| APPLICATION NO. 03 DRB-02198 | PROJECT NO. 1003110 |
| PROJECT NAME MONKBRIDGE BL. 4, LOT 5-A | |

DEVELOPMENT REVIEW BOARD--SPEED MEMO

DEVELOPMENT REVIEW BOARD TRANSPORTATION DEVELOPMENT Standard Comment Sheet

**PLAT OF
 LOT 5-A
 BLOCK 4
 MONKBRIDGE ADDITION**

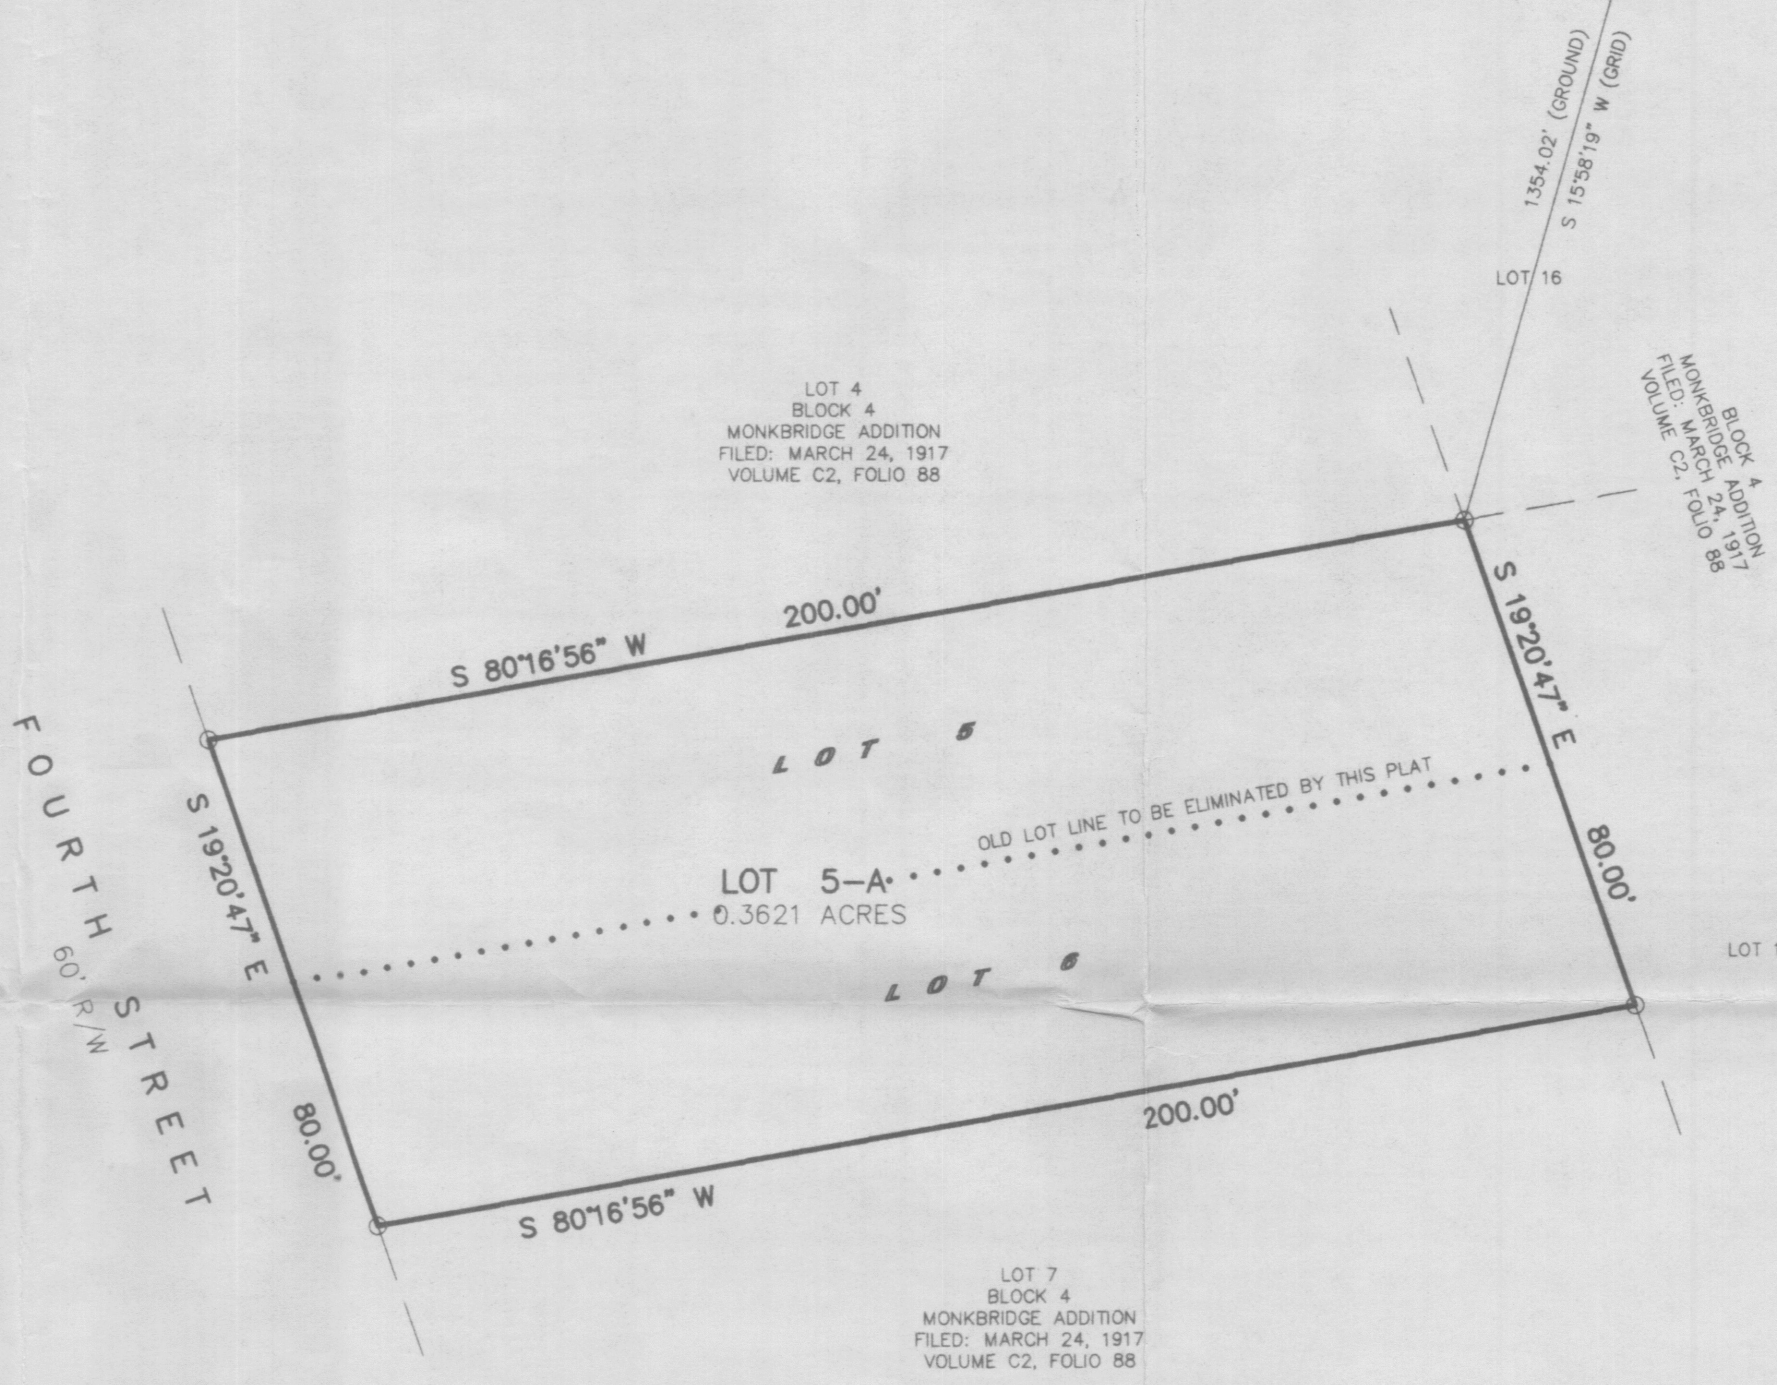
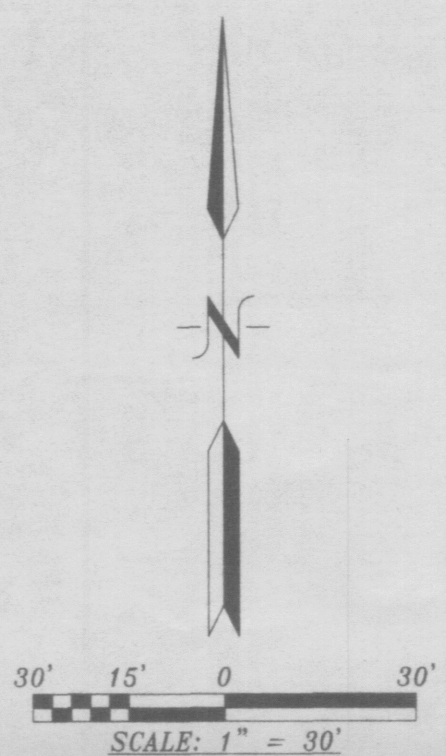
| No. | Comment |
|-----|--|
| (1) | PER LIRS 4 th STREET R-O-W SHOULD BE 80'. DEDICATION WILL BE REQUIRED |
